BPC are against the proposal DC-05 'Removal of junction for Sewage Treatment Works (and private residence) from A66, and provision of an alternative access from B6262.' We are particularly concerned about this newly changed road layout, whereby lorries going to and from the Sewage Works use a new junction with the B6262 close to its junction with A66. In particular the STP lorries travelling west to east – two councillors were informed at the Temple Sowerby Consultation that these lorries would have the option of turning back at Centre Parcs OR Coming back through Eamont Bridge and Brougham.

Drawing Title: Classification of Roads Plan Regulation 5(2)(o)
 Sheet 1 of 1

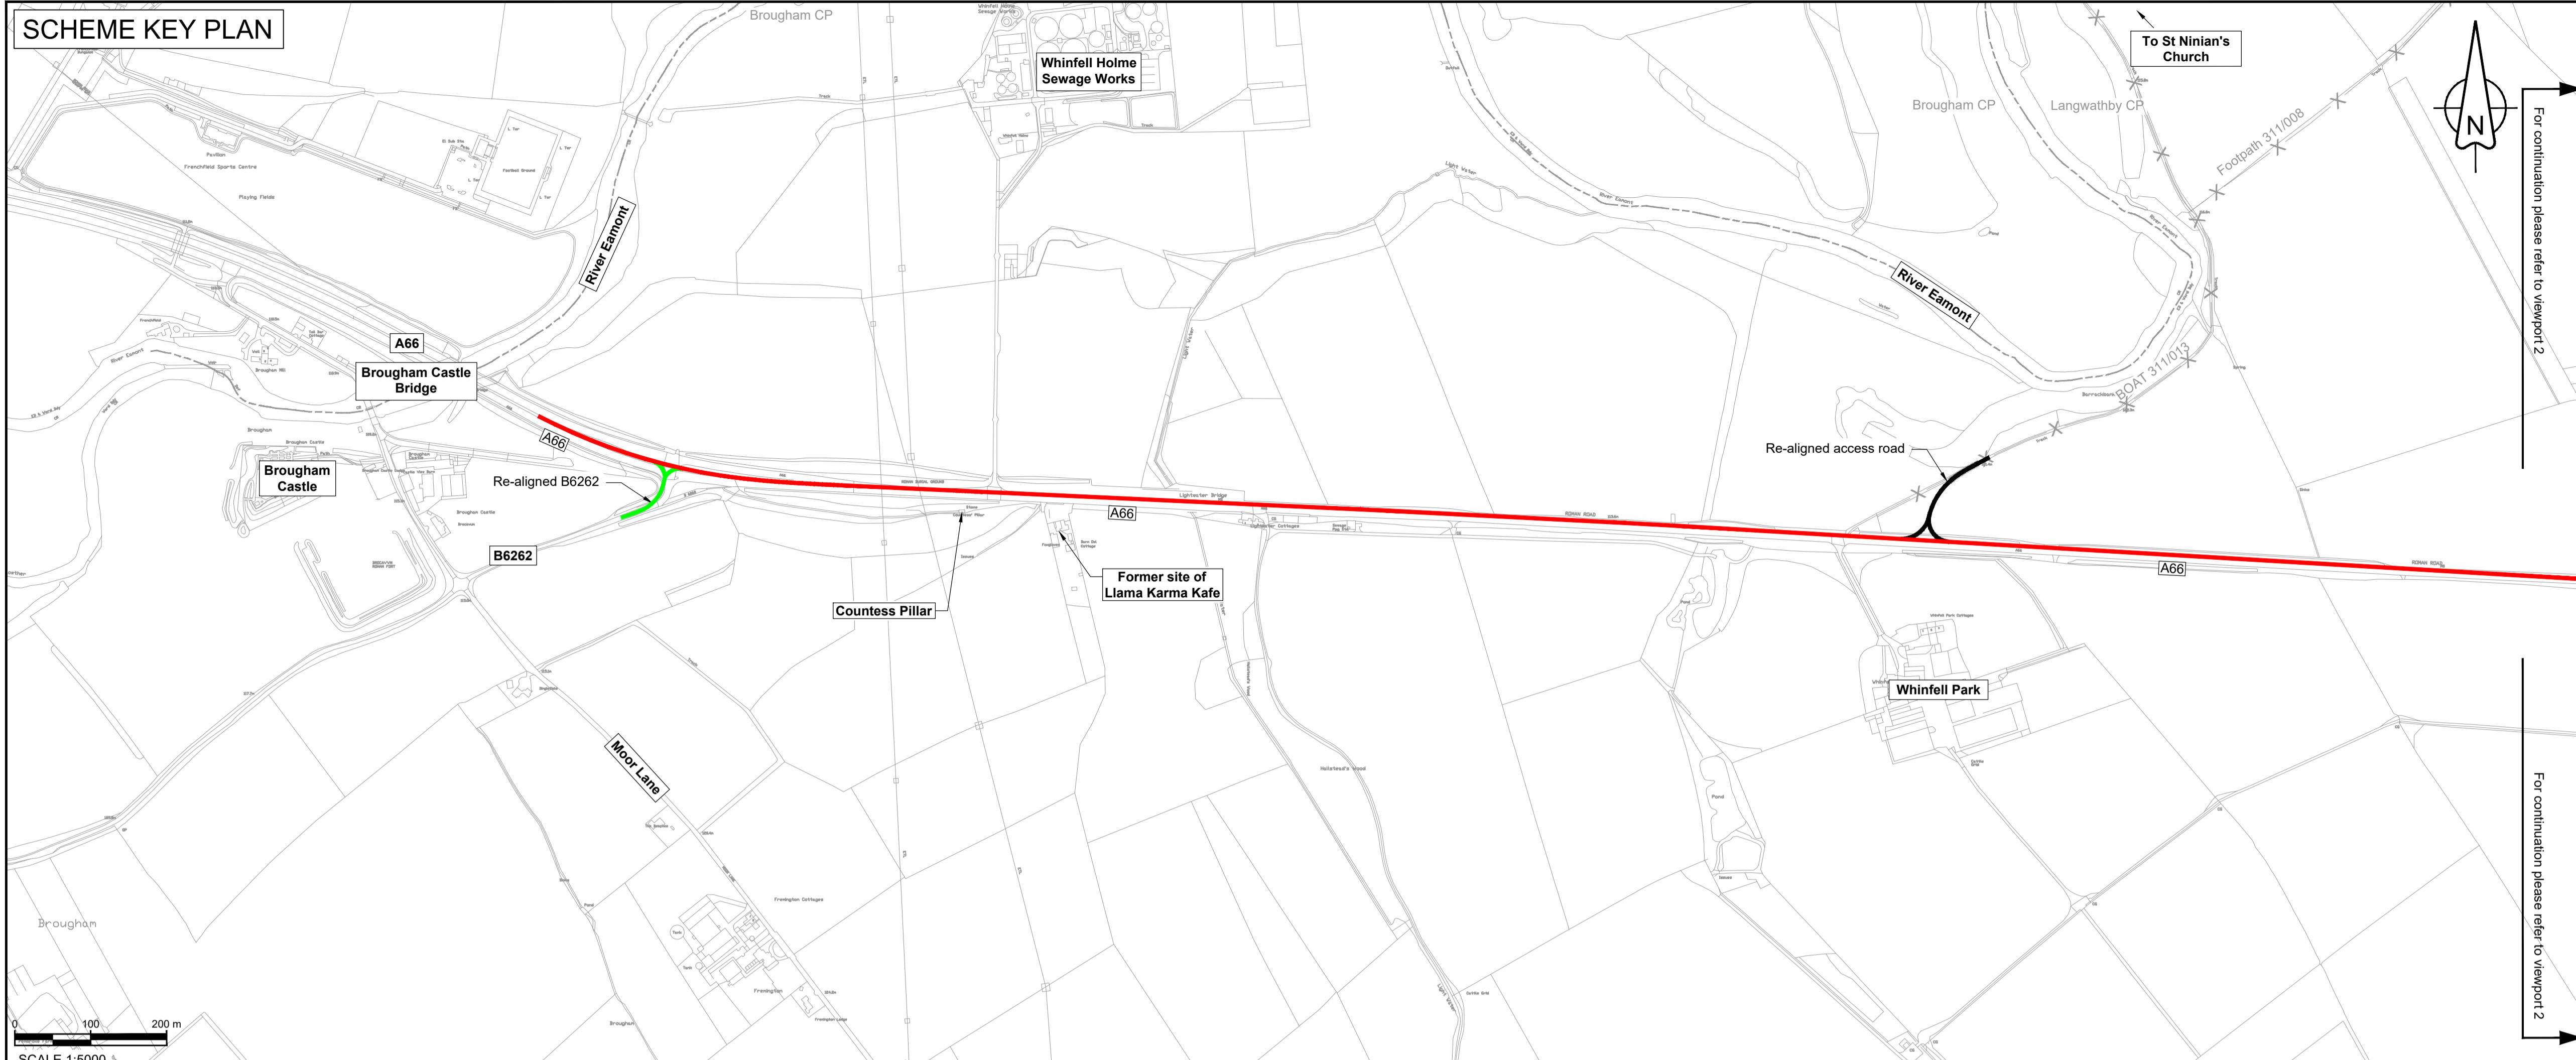
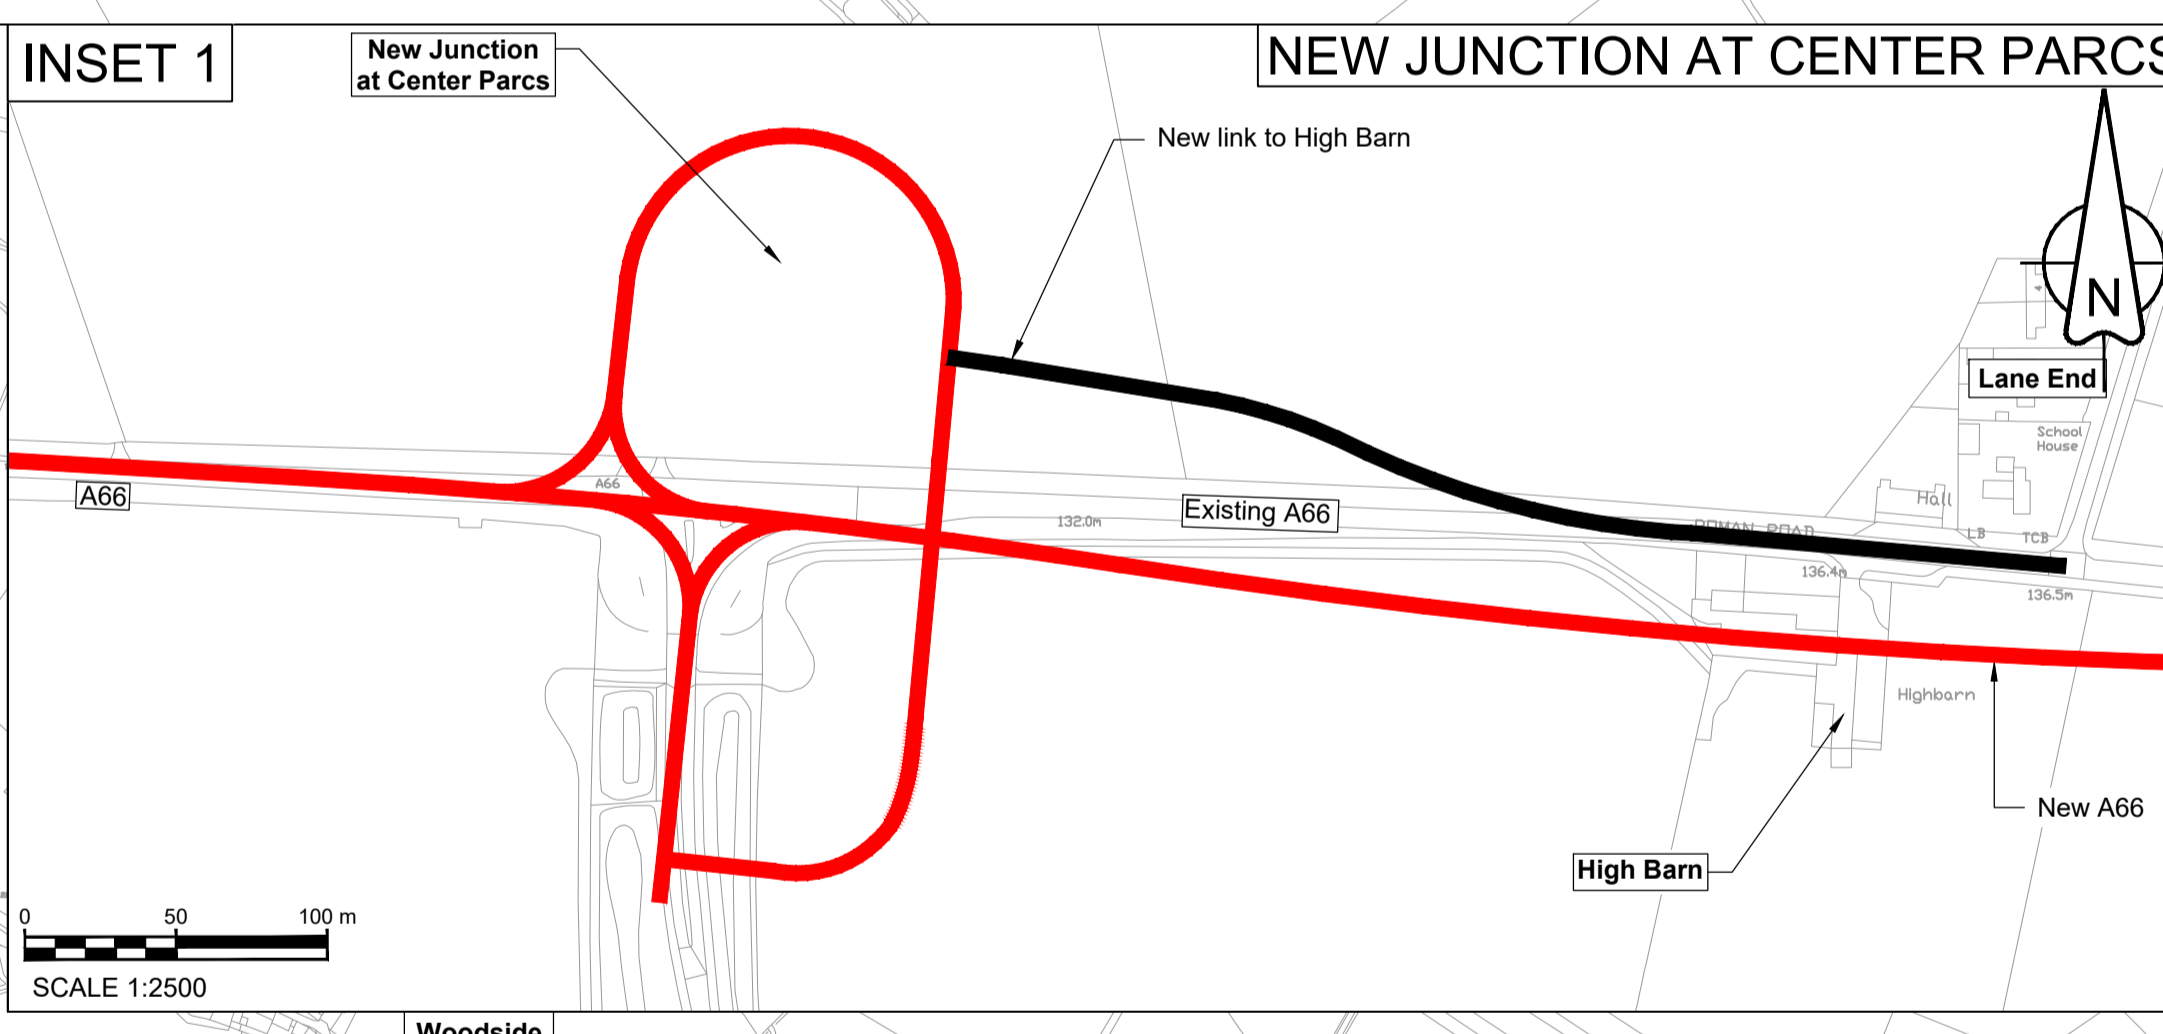
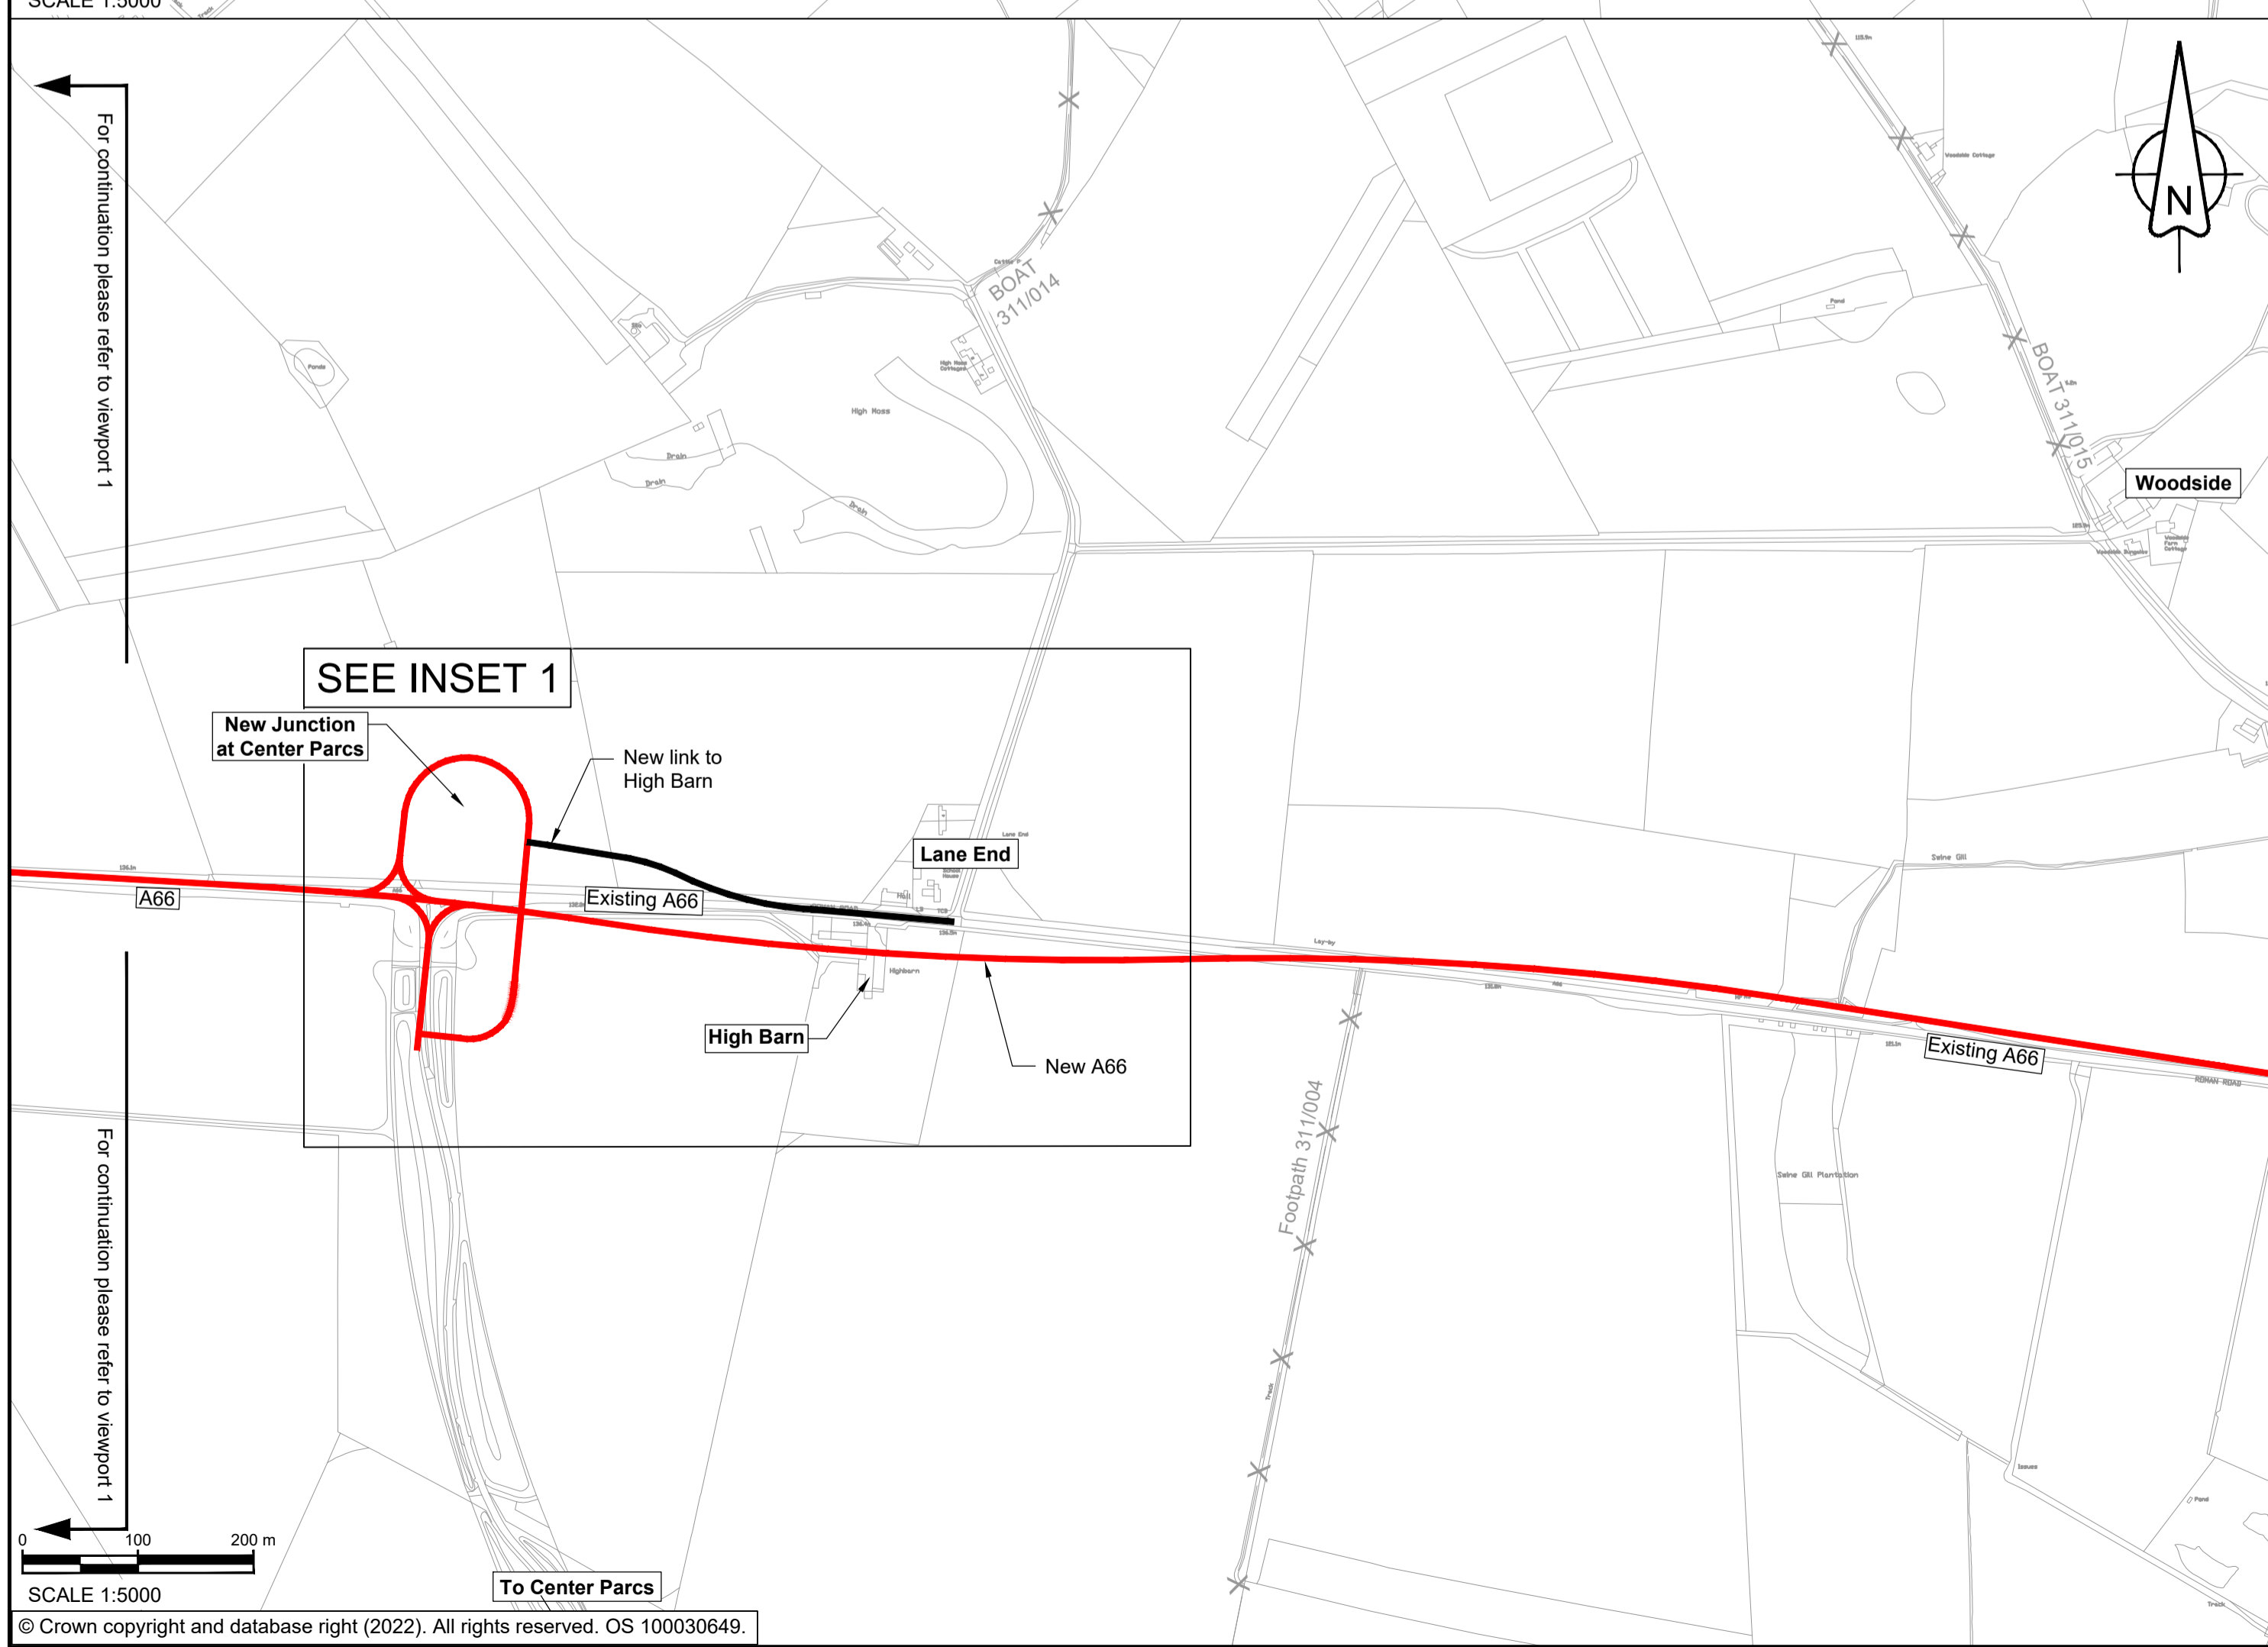
BPC are concerned for ALL roads in Brougham during the five year construction period. The volume of traffic and the safety of pedestrians in the B6262 in particular have been discussed at an on-site meeting in Sept 2020 with Traffic Maintenance Officer , Julian MacLaine. Indeed, Brougham parish Council have a further meeting this month with Laura McClellan, Traffic Management Team Leader, Westmorland & Furness Highways Department, as this is an issue which only appears to be getting worse.

Pedestrians numbers have increased and this road has become a dangerous rat run. It has become part of an established Penrith walking loop for Jubilee House, Lowther Caravan Park, a mother and toddler group and a ramblers over 60 group, visitors to 3 Historic Tourist Attractions – Brougham Hall, Brougham Castle and is St Wilfrids, Chapel. Brougham is also on The Lady Ann Way - a walk from Skipton to Brougham. It is also widely used by horse riders from stables at Clifton and Eamont Bridge. The road is also heavily used for Penrith Show , Pony Club and WW2 weekend at Brougham Hall. In addition, all roads around Brougham have farm businesses operating, which obviously adds heavy farm traffic to the roads.

Brougham Parish Council feel the need to stress with great importance that a diversion of traffic along the B6262 through Brougham is simply not acceptable, sustainable or safe for both residents and other road users in the area.
